November 5th 2009

RE: B. Proctor Short Plat SP-08-00058

James Rivard,
Environmental Health Supervisor
Kittitas County Public Health

B. PROCTOR SHORT PLAT
A PORTION OF THE SE 1/4 OF SEC. 12, T2N, 17N, R9E, 19E, W.M.
KITTITAS COUNTY, WASHINGTON

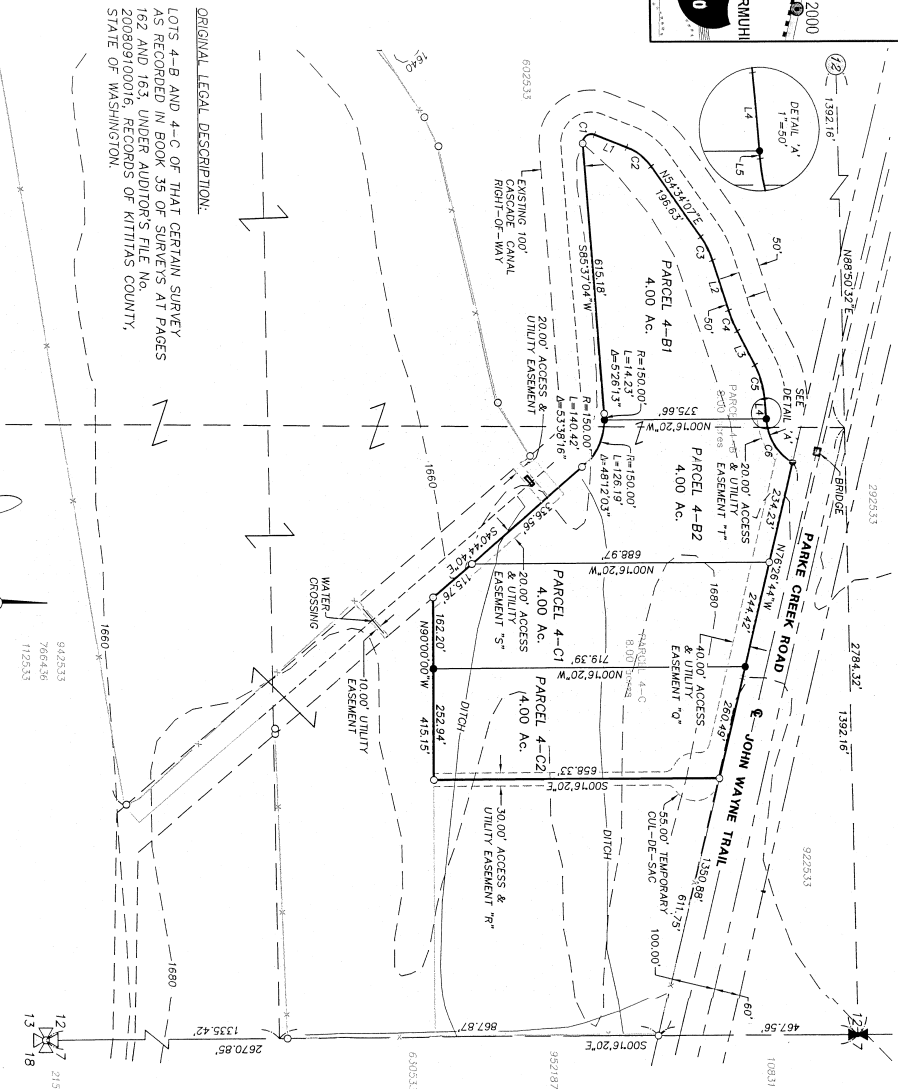
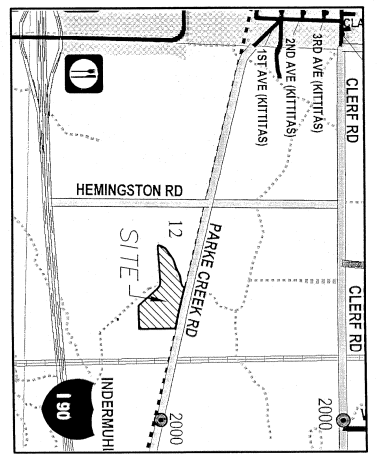
Thank you for the opportunity to comment on the B. Proctor Short Plat, SP-08-00058. All residential well connections serving the proposed lots shall be required to have meters installed. Metering results shall be recorded in a manner consistent with Kittitas County and the State of Washington, Department of Ecology requirements. This requirement to meter only applies if you rely upon the RCW 90.44.050 exemption from permitting through ecology.

The final plat notes shall include the following two statements:

"The approval of this division of land includes no guarantee that there is a legal right to withdraw groundwater within the land division. The approval of this division of land provides no guarantee that use of water under the ground water exemption (RCW 90.44.050) for this plat or any portion thereof will not be subject to curtailment by the Department of Ecology or a court of law. "

AND

"Metering will be required on all new residential well connections and metering results shall be recorded in a manner consistent with Kittitas County and Washington State Department of Ecology requirements."

The Public Health Department's recommendation shall state that Final approval be conditioned upon the developer/owner of the plat providing proof of water availability. Water availability can be provided through several different ways depending on the source of water proposed.

If individual wells are proposed for the parcels and there is an existing well located on the plat, a well log from the State of Washington, Department of Ecology and a passing bacteriological test will meet the water availability requirement. If there is not an existing well on the plat, then a **water availability report** with documentation and evidence to support the claim regarding adequate availability of groundwater for the proposed number of potable water wells must be submitted for review.

Soil logs must be performed prior to the Public Health Department recommending preliminary approval of the plat. The Public Health Department's approval of the soil logs will meet the septic availability requirement for recommending preliminary plat approval.

At this time the application does not contain sufficient information to make a determination of adequate water availability or soil assessment to determine the land area is suitable for onsite sewage systems. The above mentioned items need to be submitted to the Public Health Department in order for the plat application to be recommended for approval.
